From: Katherine Jenkins [REDACTED]
Sent: 20 February 2019 14:50
To: Laura Gibbons
Cc: Andrew Wood
Subject: Re: Planning Application FG/220/18/PL : Land adjacent to Elm Lodge, Tamarisk Way, Ferring, West Sussex BN12 5ER

Subject: RE: Planning Application FG/220/18/PL : Land adjacent to Elm Lodge, Tamarisk Way, Ferring, West Sussex BN12 5ER

Laura Gibbons, MEng, GMICE
Engineer (Drainage & Coastal)

EXISTING POND ACCESS
PLAN

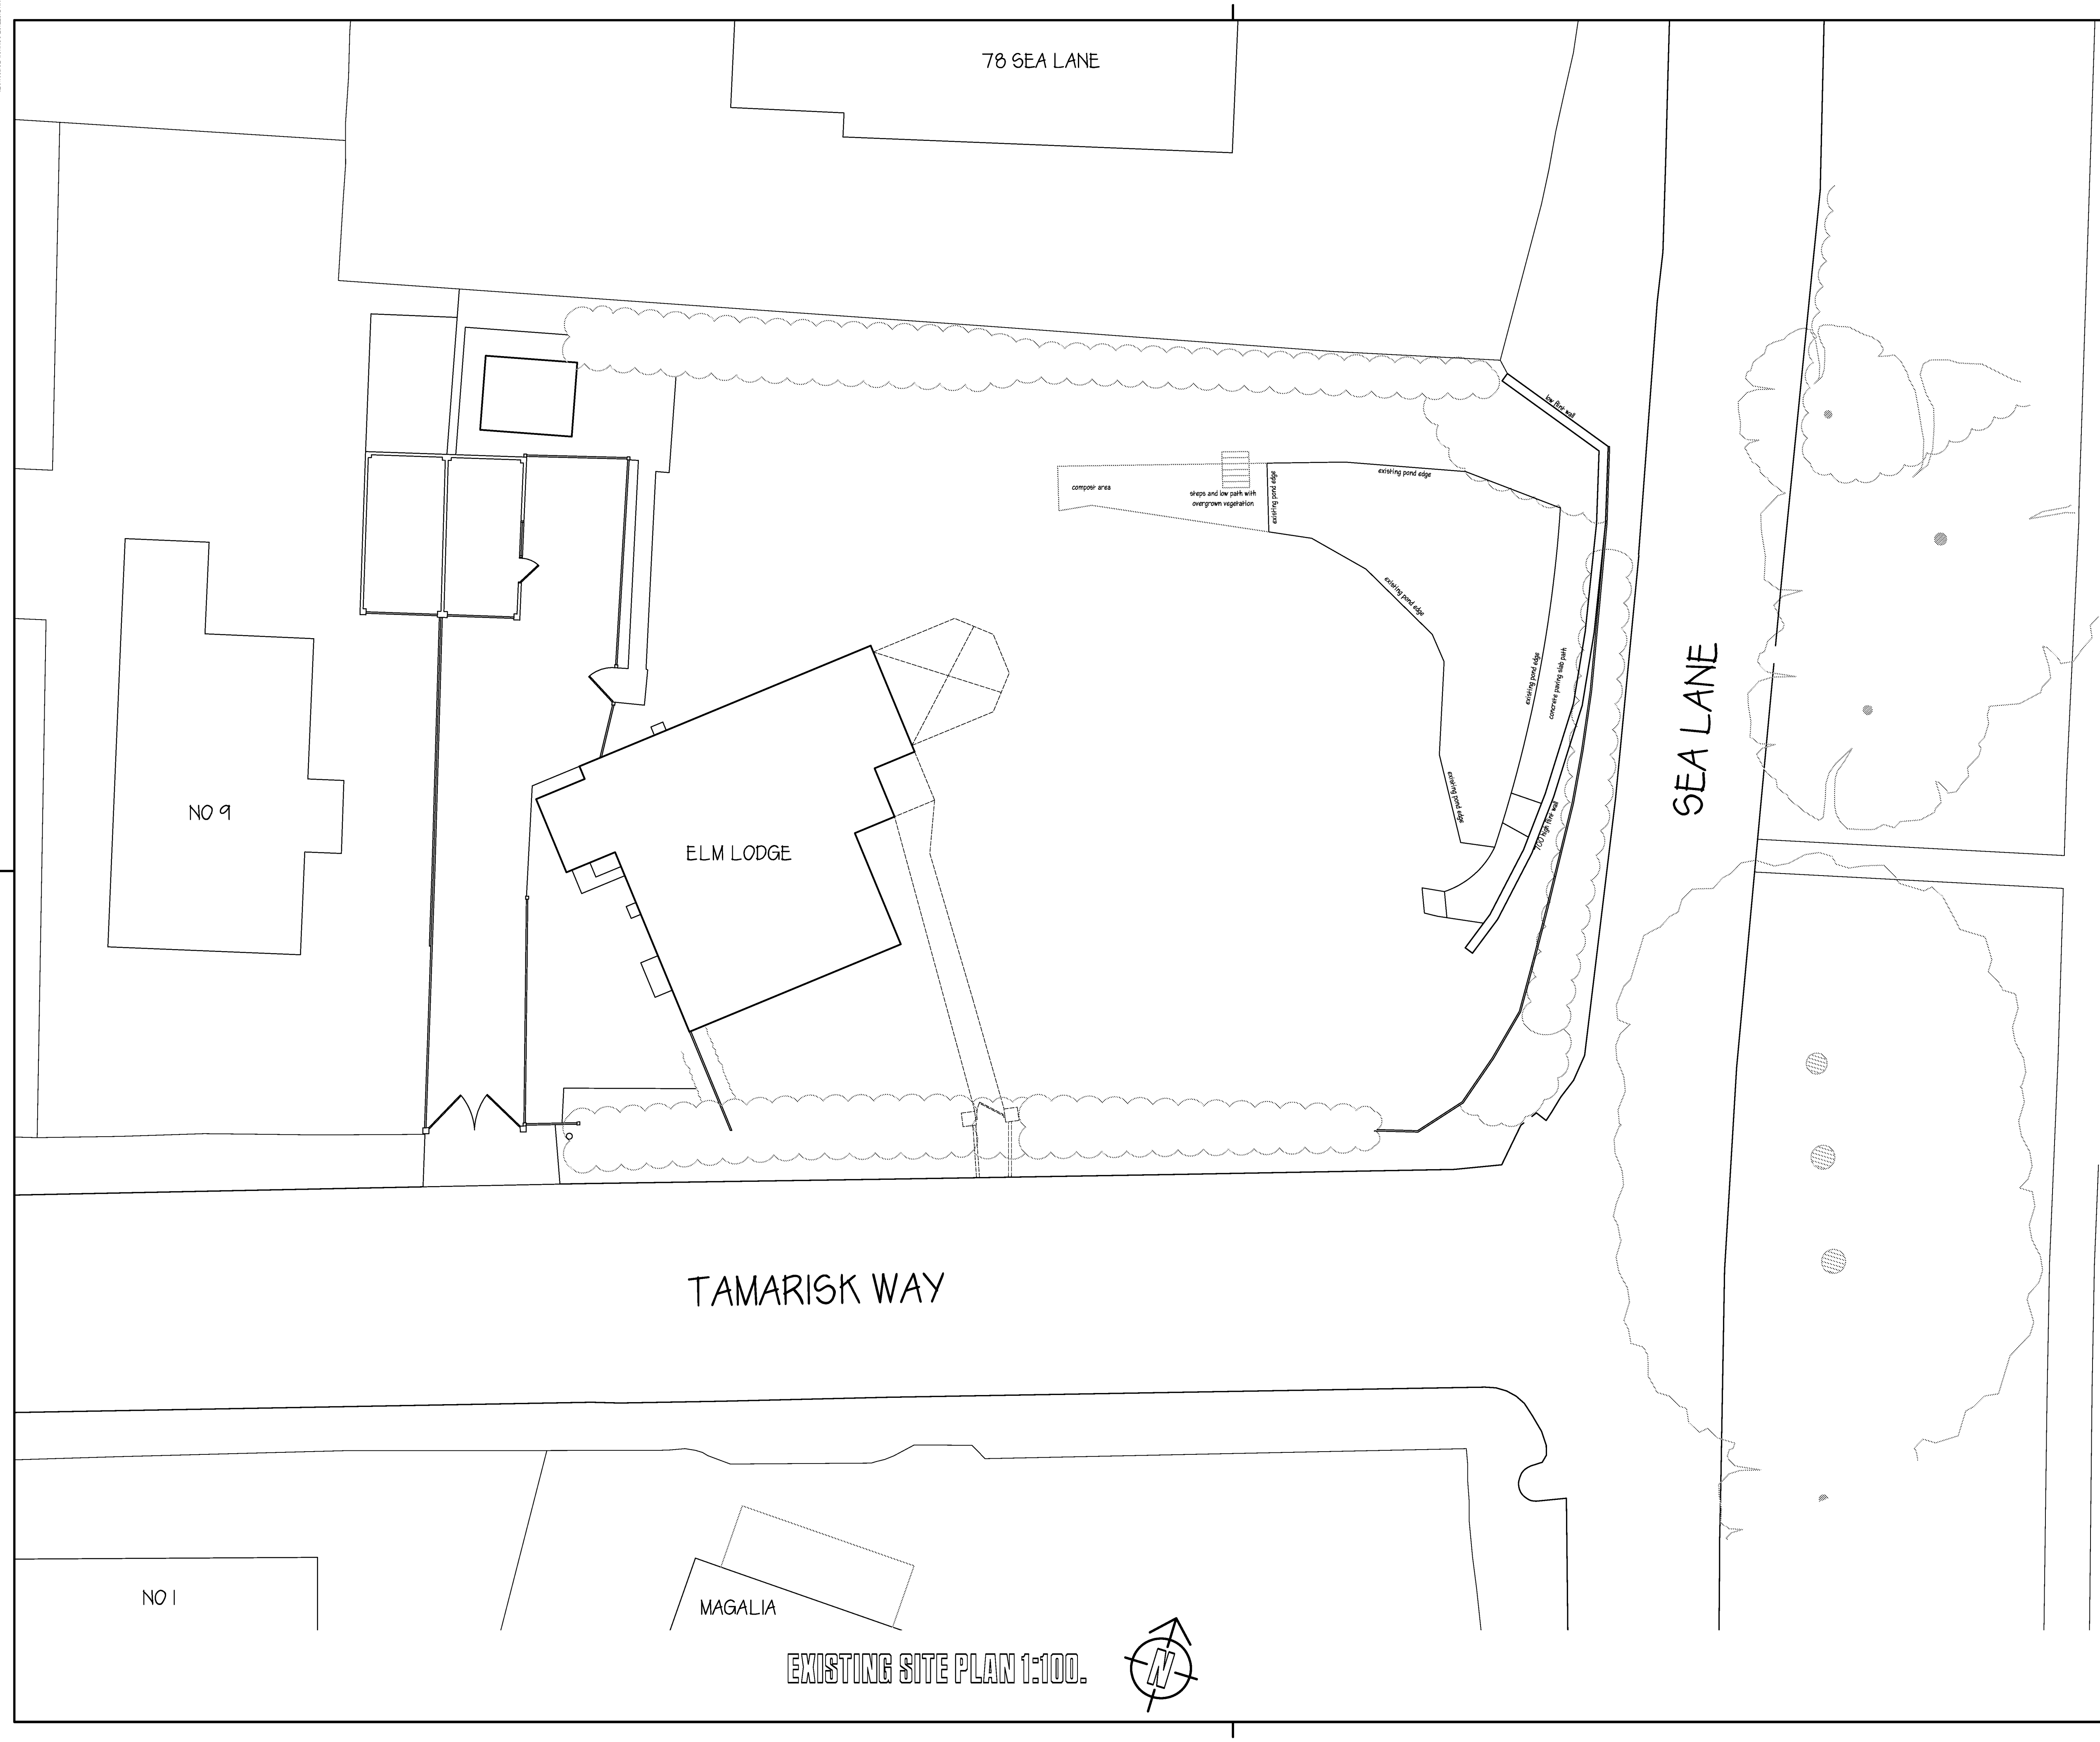
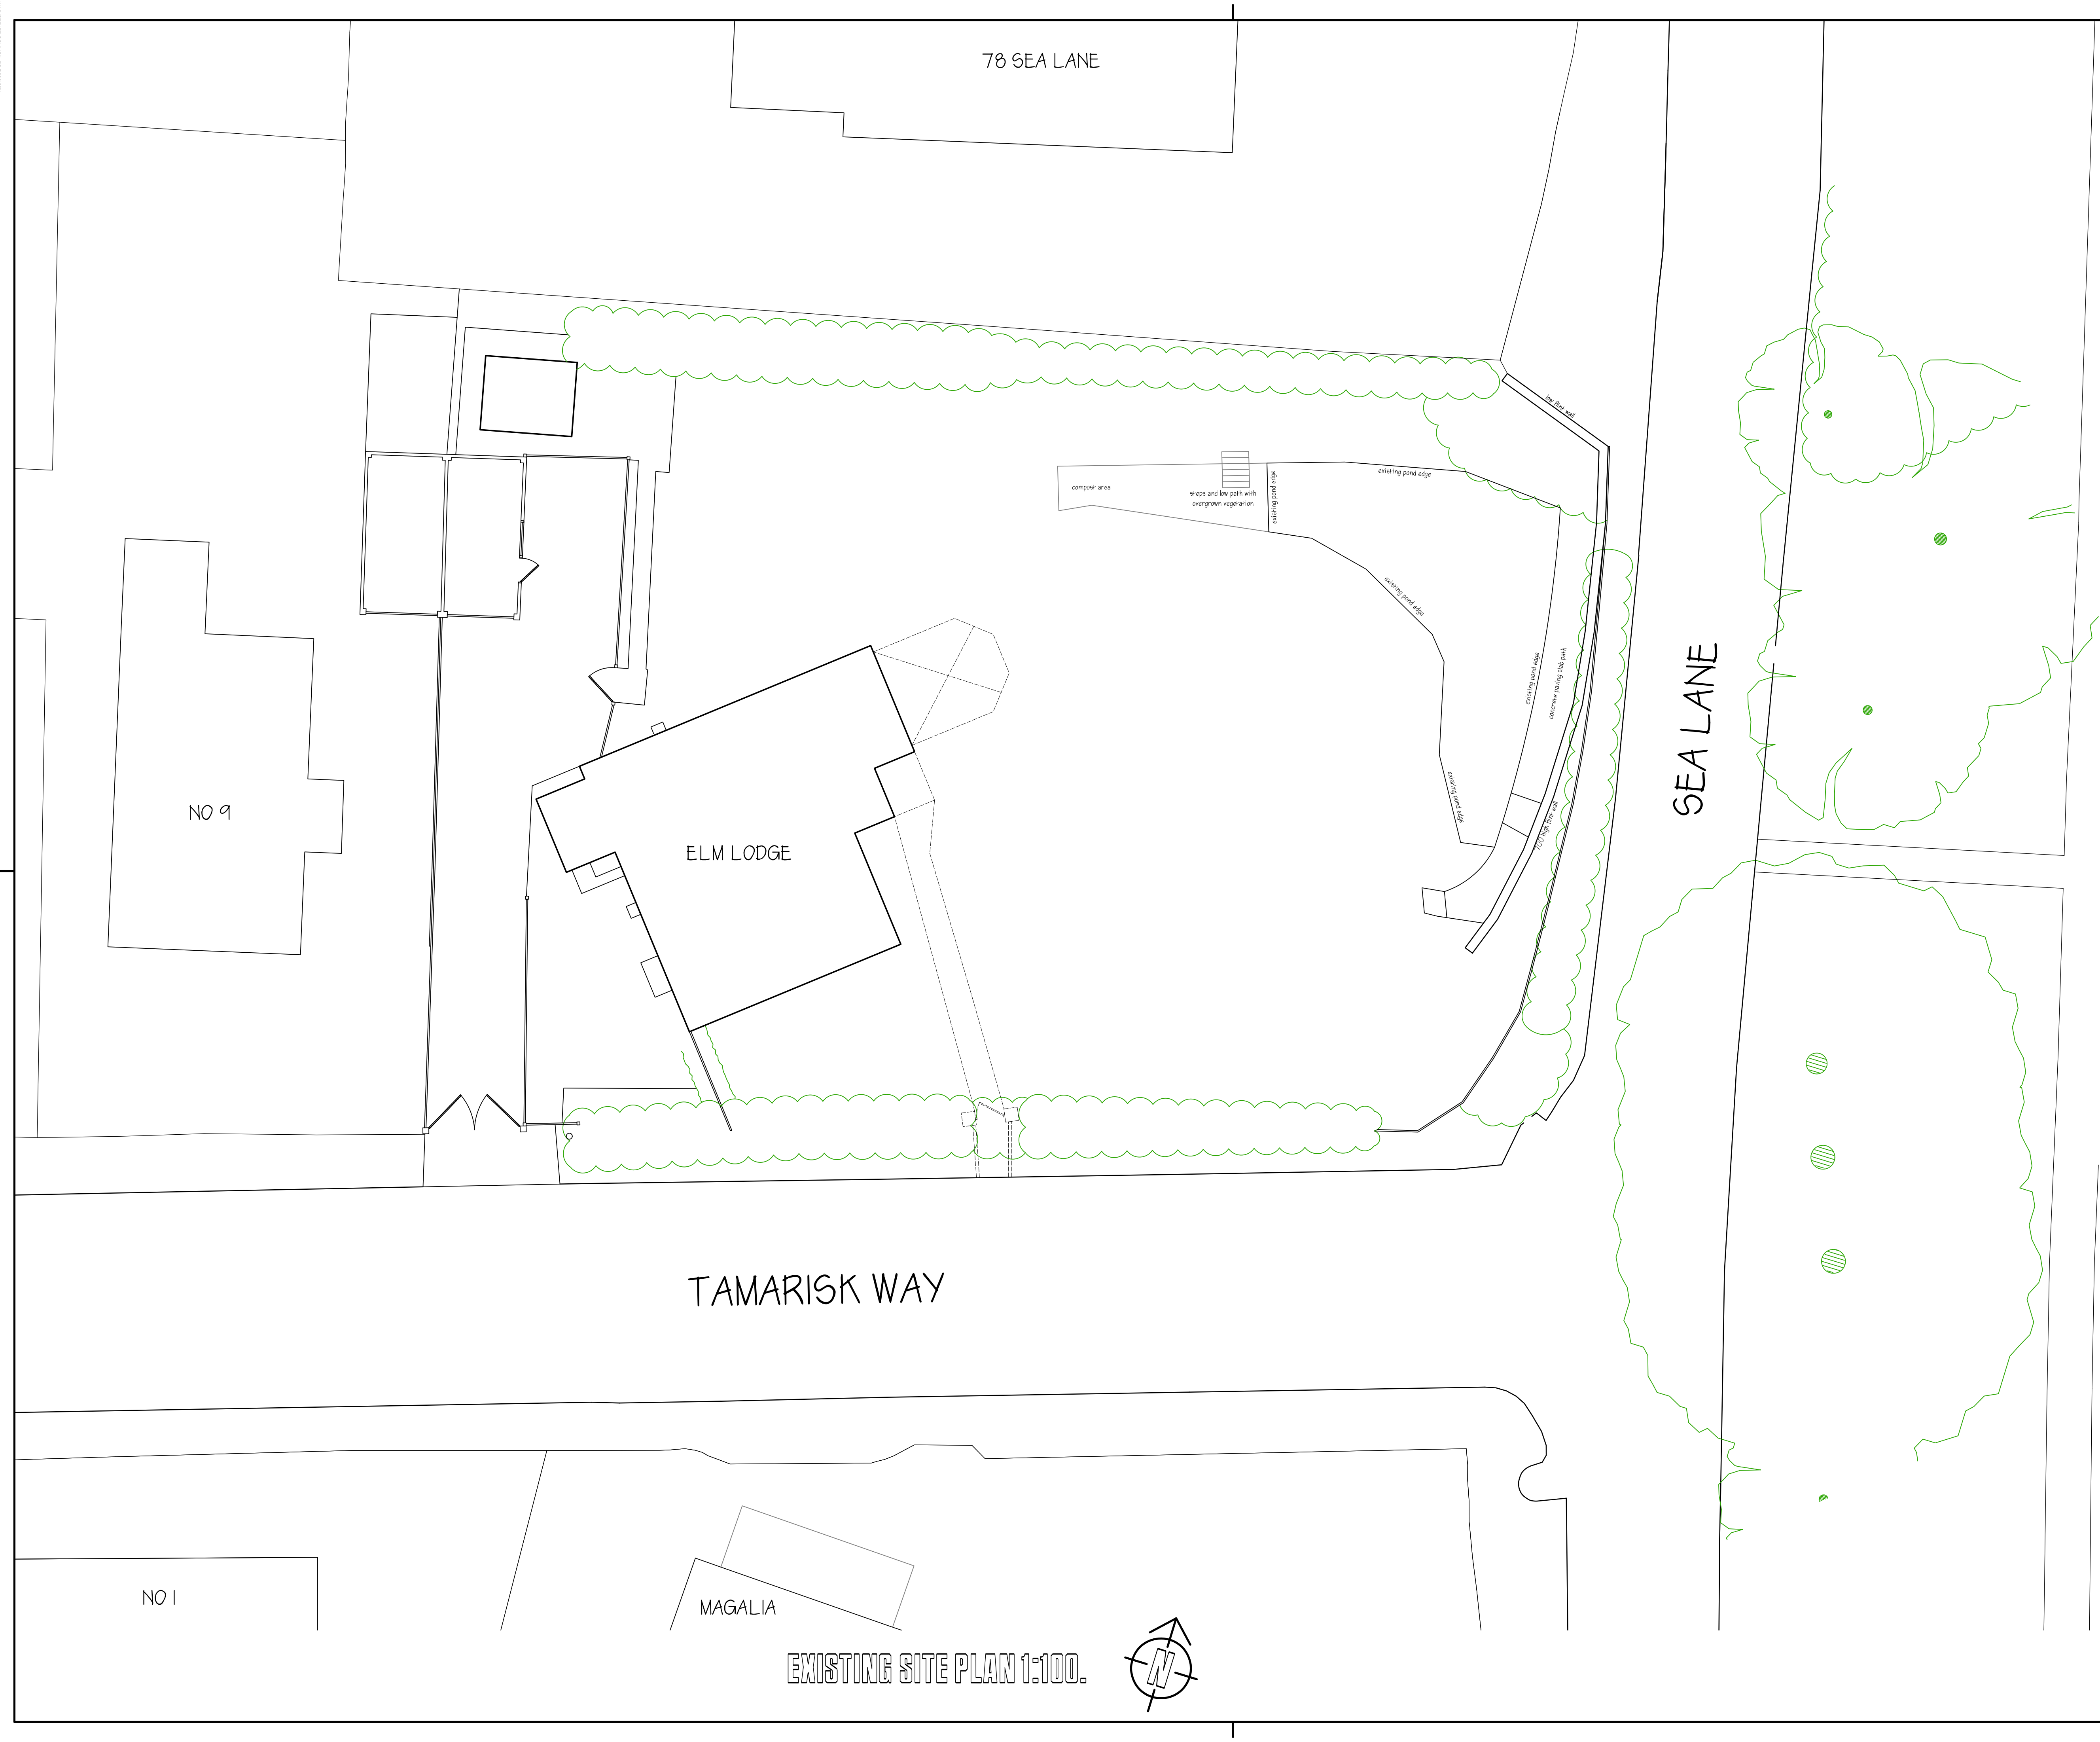
3. It is my belief that there is no way to get to the northern and western portions of the pond without tracking through the pond itself. This would mean that maintenance would have to be completed in the summer by the landowner when water levels are lower. This would then be within nesting bird season. I would much prefer an access to be provided around the pond. I note that you state the 1m wide path to the east could take plant but this plant would not be big enough. As explained above, we as landowners can continue to access the pond from all sides, with 3m to the West, North and South East. We cannot understand what plant would ever be required (given no plant has ever needed to access the pond before, and any plant necessary for carrying out works to the pond can have full access from all sides as part of the building works) that would ever be larger than a small digger, which can easily be maneuvered up the 1m side access to the west of site and around the rear.

Further to our meeting at the land adjacent to Elm Lodge, Tamarisk Way, Ferring, West Sussex BN12 5ER on 12th February 2018, please find attached the existing and proposed pond access plans as requested. These show the existing pond to be retained in its entirety, with 3m access provided should Arun District Council ever need to access our property to maintain the pond. We hope these now alleviate your concerns regarding potential future access. We also note that the path to the east of the pond is also over 1m wide, which can currently comfortably accommodate a 1.5 ton digger to carry out any works. Given that there are multiple points of entry along the edge of the pond, any further work can be carried out from within the pond.
